PLANNING CONSULTATION REPLY

APPLICATION: 1 Wheatcroft Gardens, Penistone, Sheffield, S36 6GA.

Prune back overhanging vegetation from woodland by reducing back between 2 and 3m to boundary line within TPO 22/1999

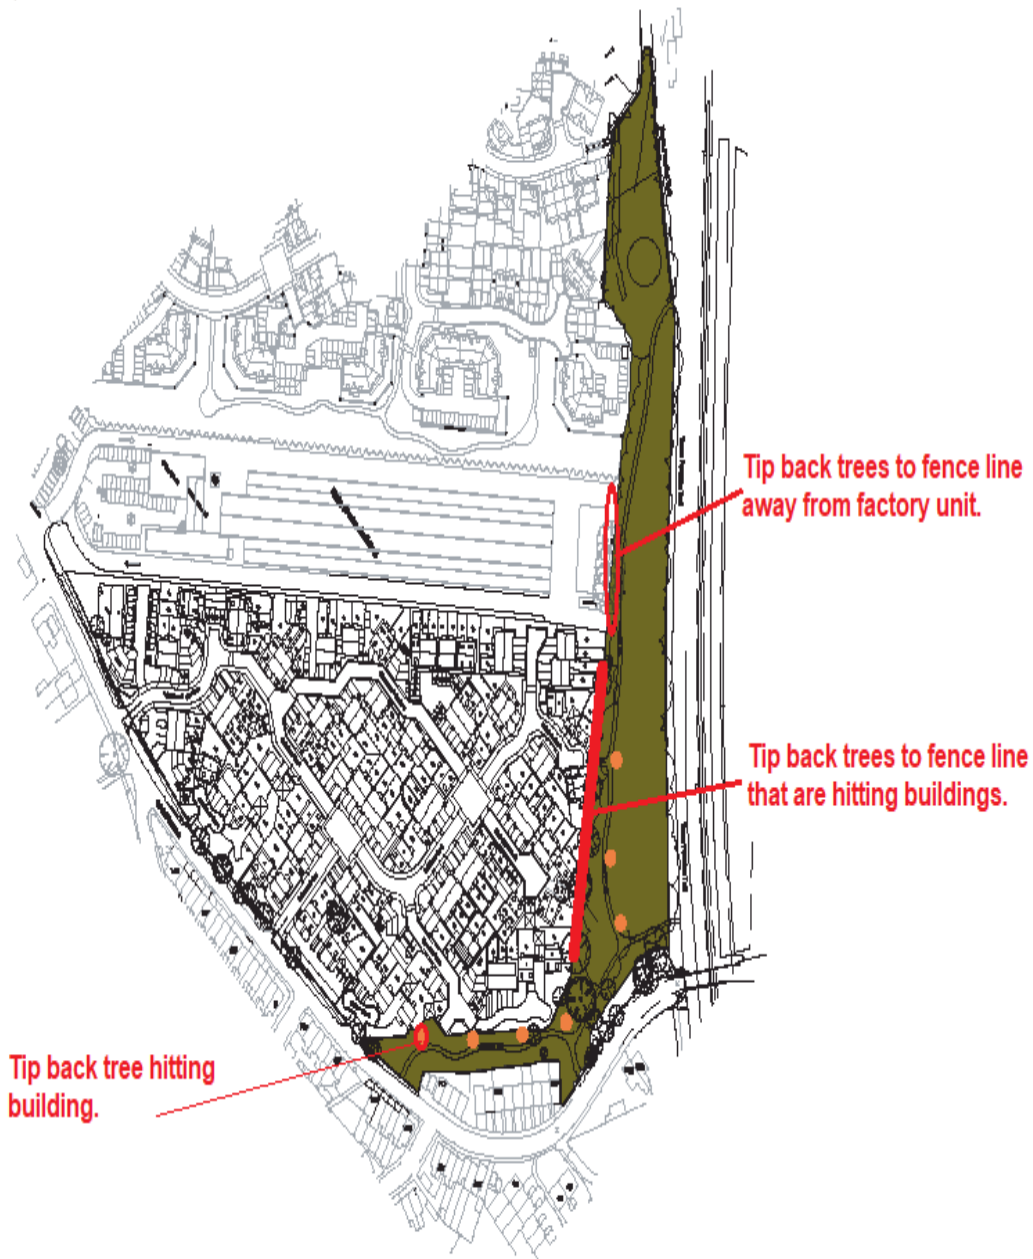
This application is to prune back the trees to the boundary line between 2 and 3m in the areas marked on the plan. The trees are all young to semi mature specimens specimens growing as part of the landscaped area of the development. As part of the woodland group the trees subject to this application do have significant amenity value.

The pruning works proposed are to provide adequate clearance from the neighbouring properties. Although significant, the level of work can be accommodated in this instance as it will act to train the trees back away from the property and give a pruning reference point for future maintenance as the trees grow and mature. As such there is no objection to this application from an arboricultural perspective.

The works are to prune the trees only and not to remove any trees, therefore concerns raised with regard to the possible removal of trees and impact upon soil/foundations is not a concern.

APPROVE

Not less than five working days notice of the date of the proposed work shall be given to the Local Planning Authority and the tree surgery shall be carried out to the standards set out in BS3998.
